Thanet Extension Offshore Wind Farm

Annex A to Appendix 31 to Deadline 5
Submission: Log of Changes to the draft
Development Consent Order

Date: April 2019

Revision E

Onshore Street Work Plans - Sheet 1 of 2

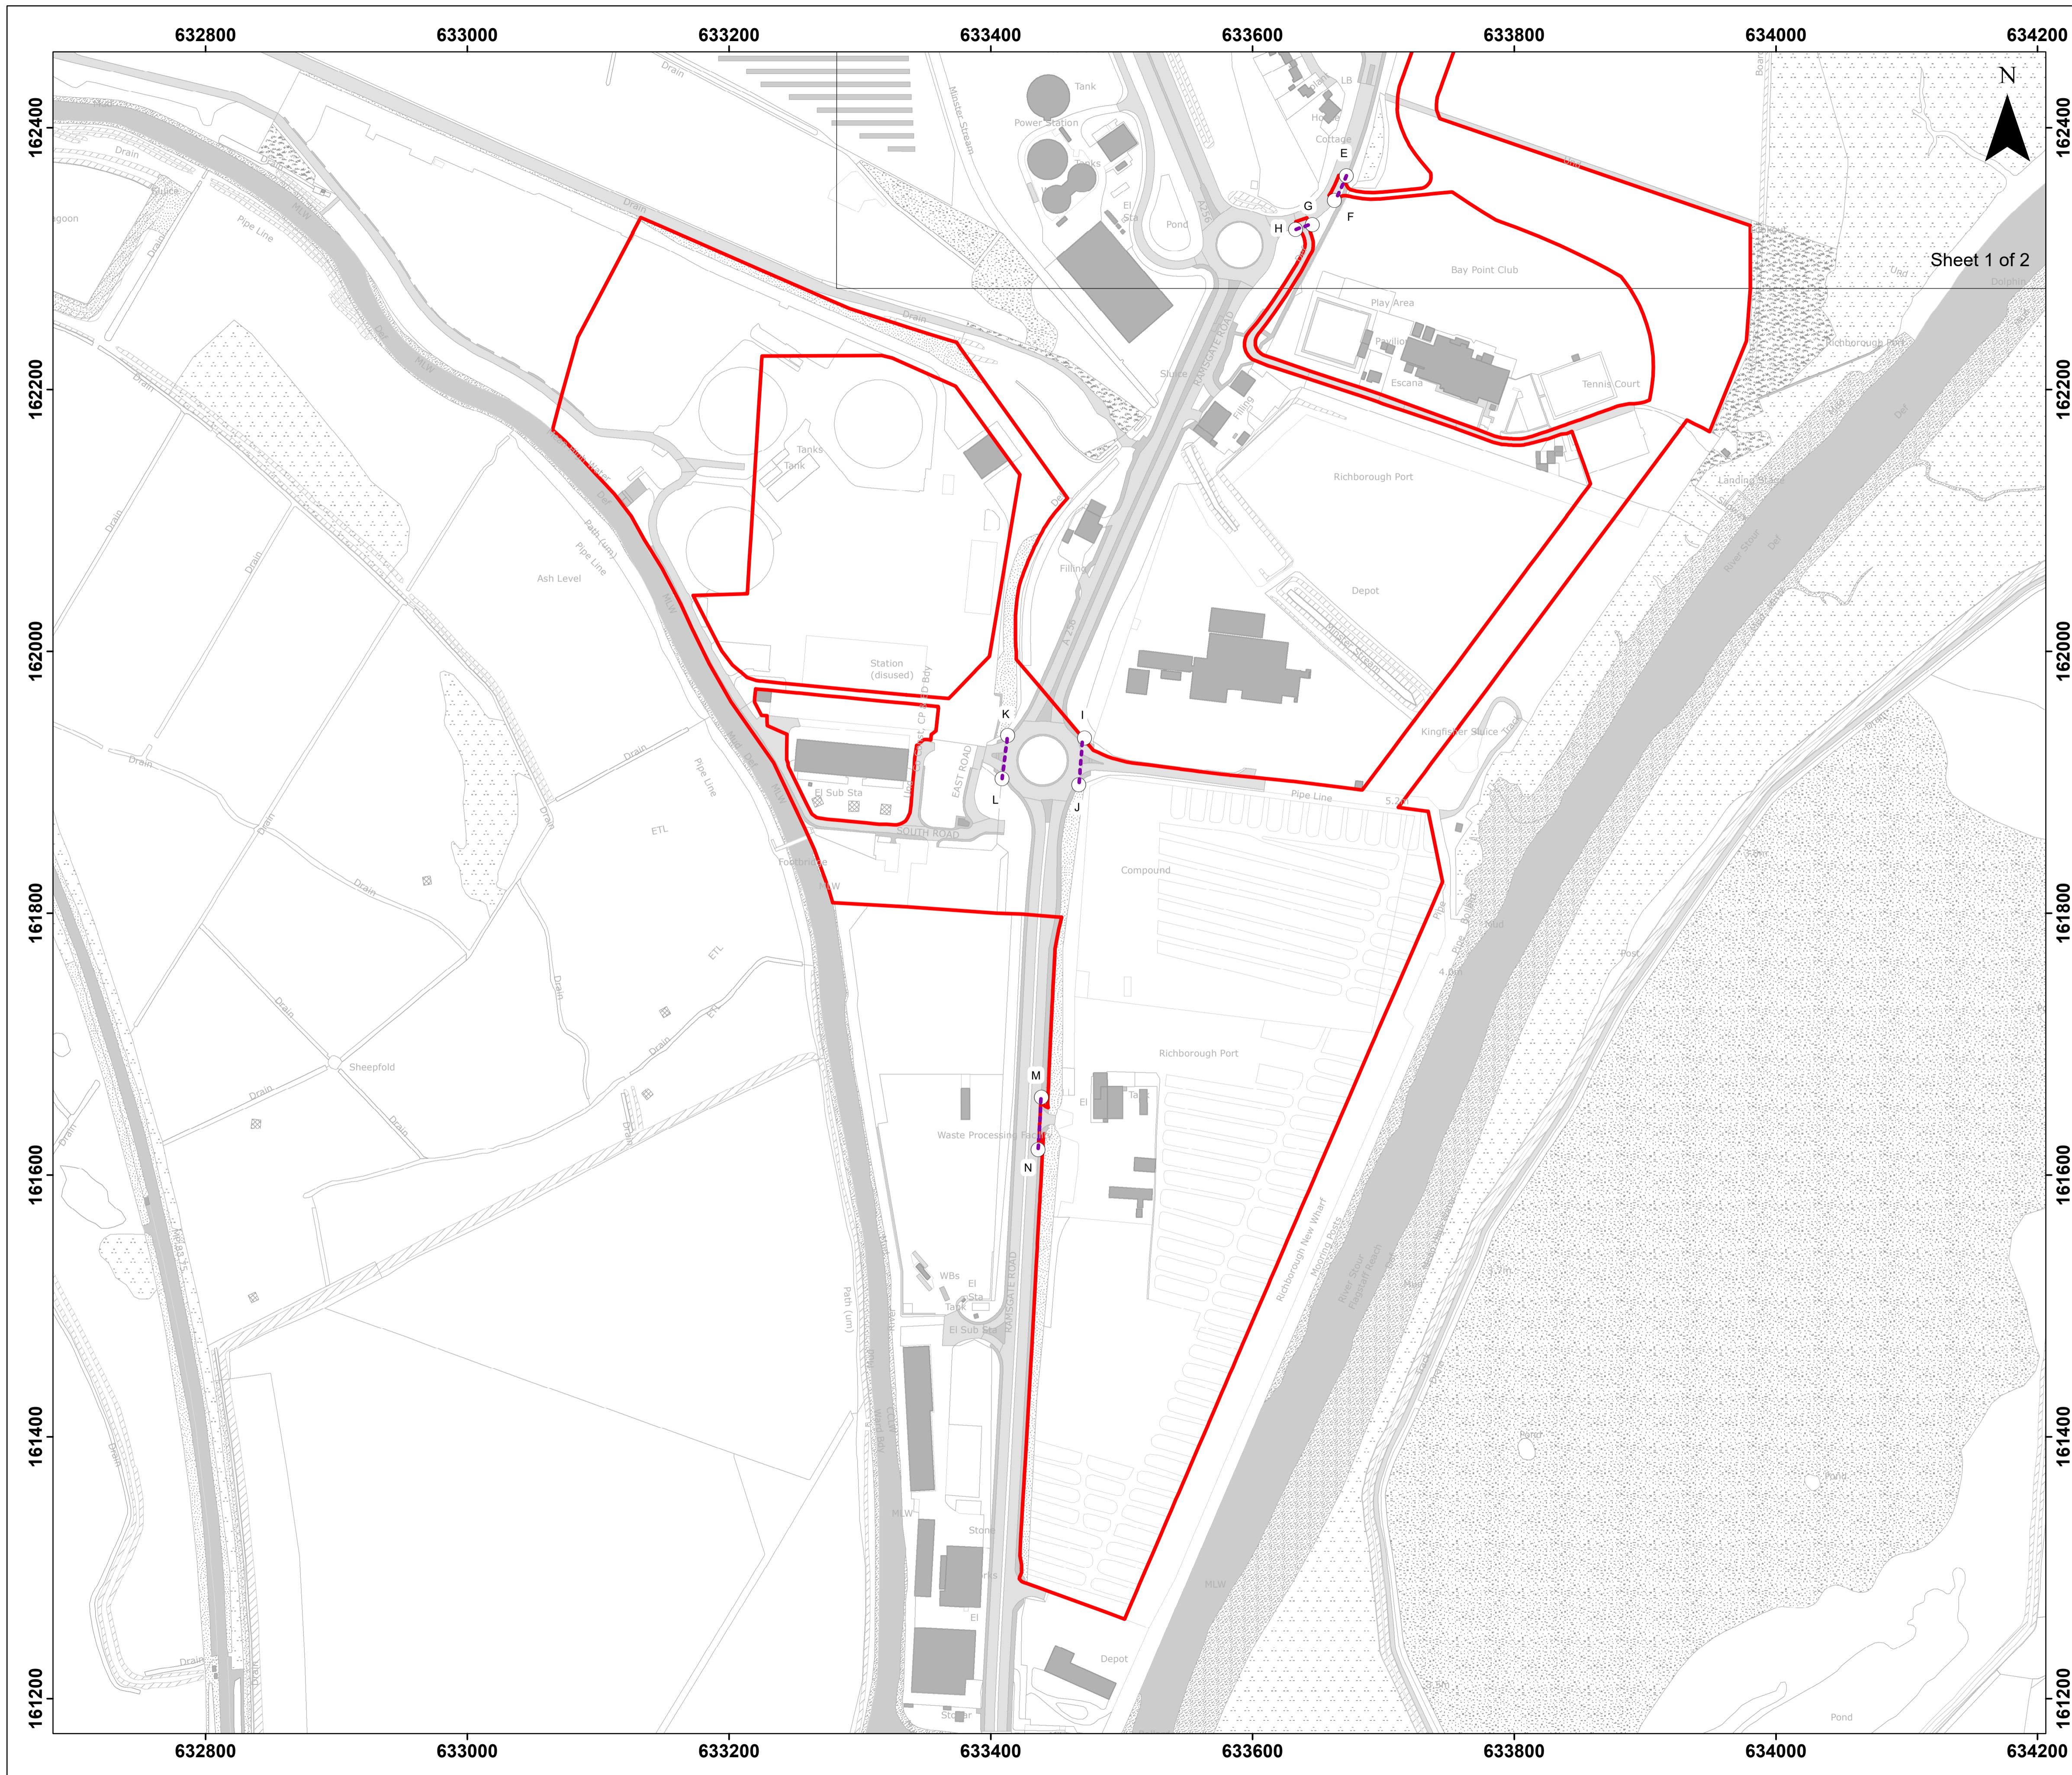
Ref	DCO Ref.	Rationale for change	Change made	DCO Version
1.	Schedule 2	In their Section 51 advice issued to the Applicant, the Planning Inspectorate noted that: “In relation to the dDCO Schedule 2, the dDCO refers to the works plans. This should be the onshore street works plans.”	The wording has been amended throughout Schedule 2, for example – <i>SANDWICH ROAD at reference point A-B on the <u>onshore street</u> works plan</i>	2
